CITY OF ALBUQUERQUE

**Re: Explore Academy 6600 Gulton Ct. NE
Traffic Impact Study/ Neighborhood Impact Analysis**
Engineer's Stamp dated 01/22/2021 (E17D012)
Received 1/25/2021
CABQ Planning Transportation approved

Figure 4: Proposed Site Plan

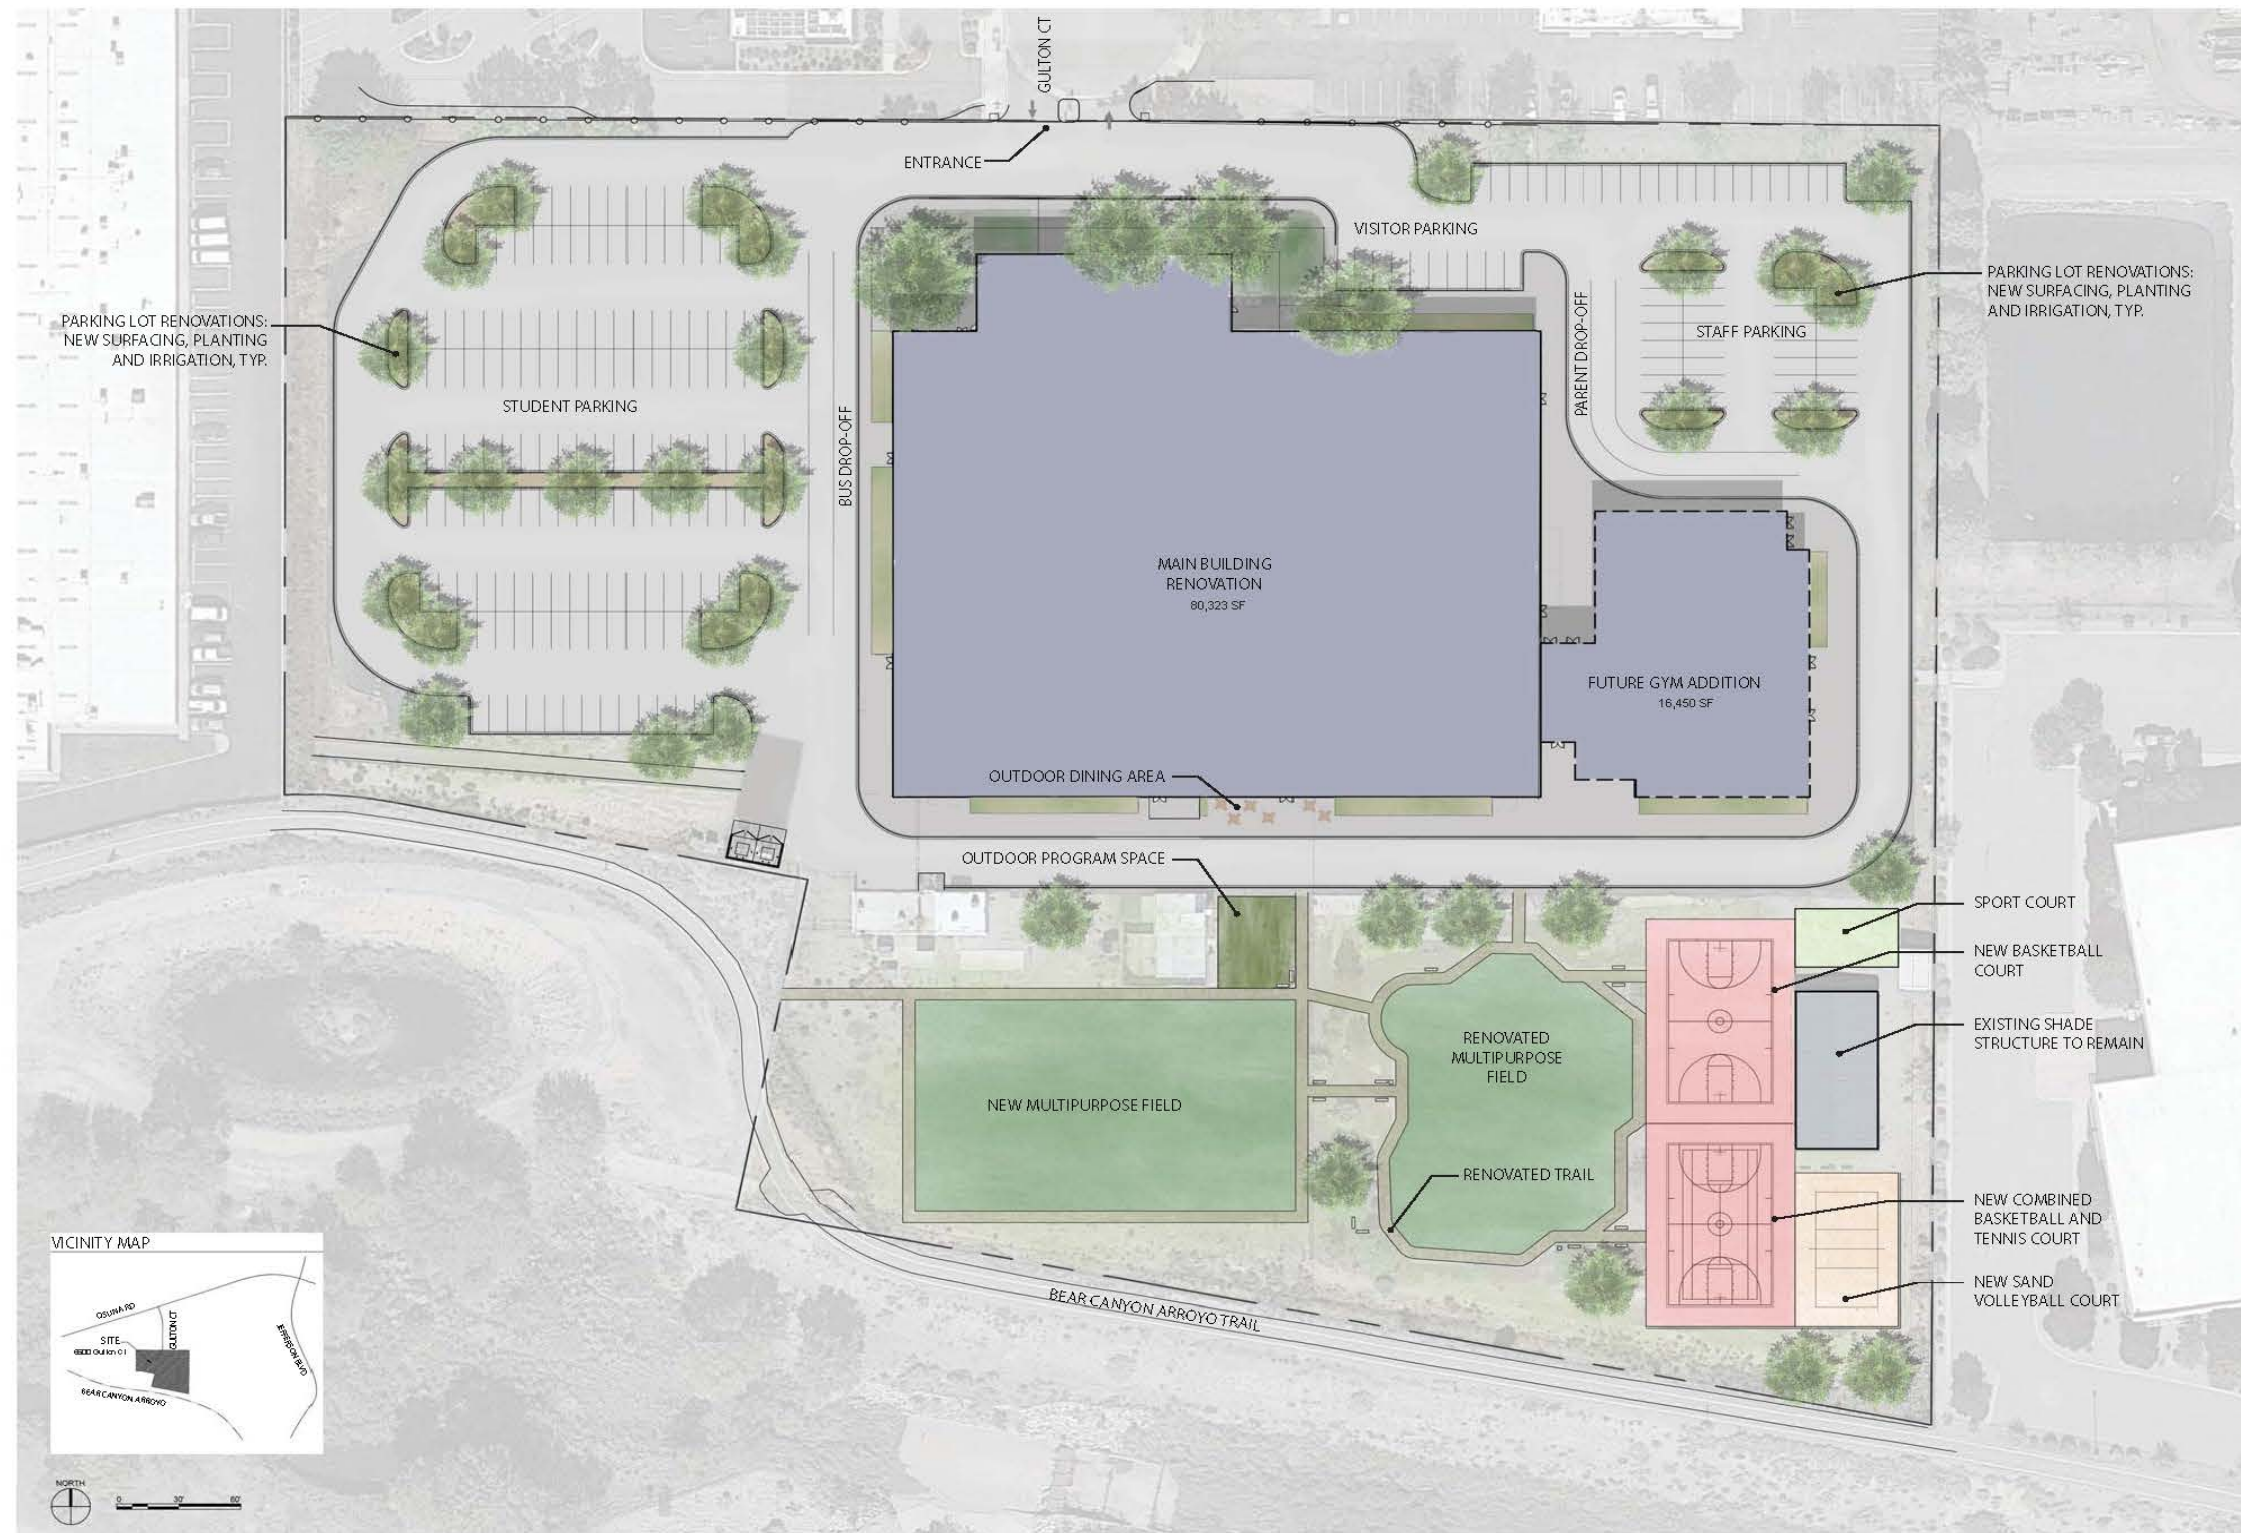
On-Site Access Driveway

1. The existing concrete drivepad should be maintained and modified as follows:
 - a. Provide lane striping to designate a 2-lane approach in the southbound direction, consisting of a solid white stripe between lanes and a solid yellow line on the left.

- b. Provide directional lane arrows to designate right- and left-turn lanes.
 - c. Install signs directing traffic to parking and drop-off areas.
2. Widen the driveway to include an egress lane for exiting traffic. The design vehicle should be a school bus.

3. Provide a channelization island between ingress and egress to separate inbound and outbound traffic.
4. Provide pavement markings at the entrance to direct traffic with:

- a. Stop bar for eastbound and westbound traffic in the main east-west drive aisle.
 - b. Center striping to delineate directional traffic.
 - c. Directional pavement arrows.

- d. A crosswalk from the sidewalk at the front of the building to the existing sidewalk on Gulton Ct. and the addition of an accessible ramp in front of the building.

- e. Signs to direct traffic to the respective areas including bus drop-off, student parking, parent drop-off, staff, and visitor parking.
